Epping to Thornleigh Third Track Proposal. Application number SSI 5132.

I/we object to the Epping to Thornleigh Third Track Proposal and consider that the EIS is inadequate and does not address the full impact of this proposal. It will cause untold damage to the health of residents and to the fabric of the Beecroft Cheltenham Heritage Conservation Area. Do not approve this project, reconsider the alternatives and protect the community.

Figure 5.6 Cross-section and elevation - New Cheltenham Station concourse building
Note: Indicatively added to future design

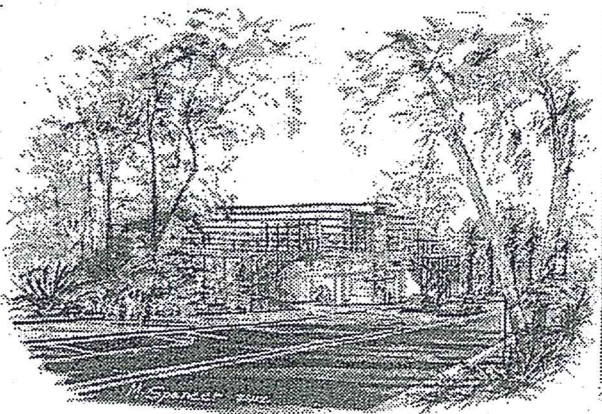
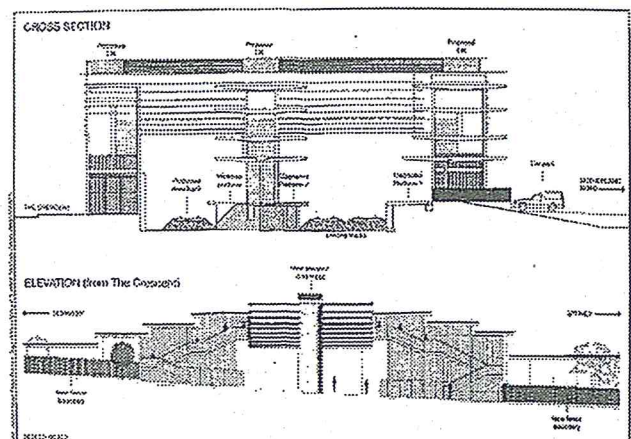
- The proposed redevelopment of Cheltenham Station shows no regard for the HCA. The visual impact of the proposed 13m high glass and steel concourse is totally unacceptable in this HCA.

Concept design drawing of proposed changes to Beecroft Station (Parsons Brinckerhoff 9/3/12). Former side platform shaded in pink.

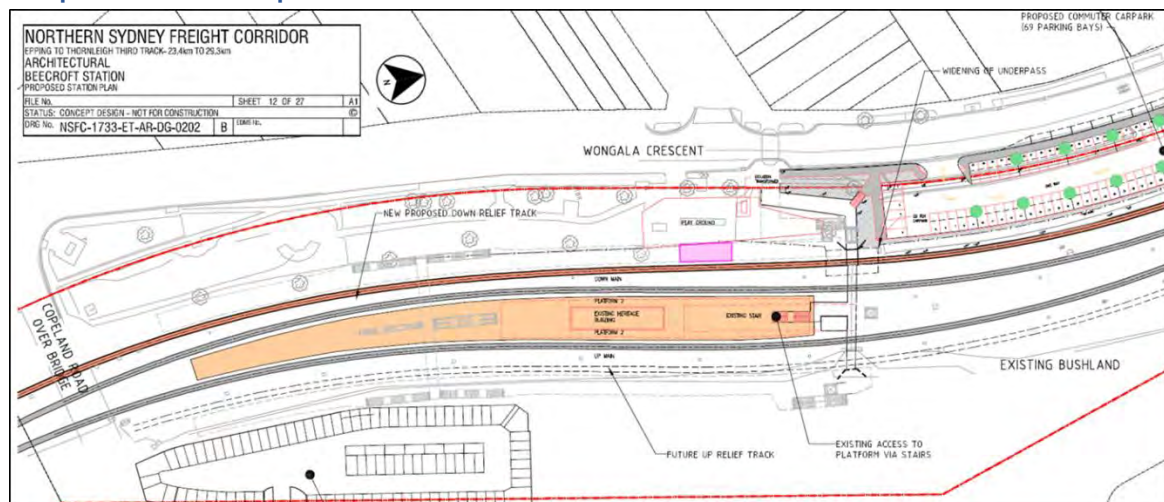
- There has been inadequate assessment of the project's impact on the fabric of the Beecroft Cheltenham Heritage Conservation Area (HCA).
- The plan given for Beecroft Railway station Precinct is vague. The relationship to the trees, playground and original 1895 platform located south of the present station is not shown. A fourth track is shown on the eastern side. The plan does not include urgently needed lifts to allow disabled access at Beecroft Station.

- Beecroft Station Gardens have a heritage listing with Hornsby Council but the impact on them has not been adequately addressed. No arborist's report is given for the trees which will be removed.
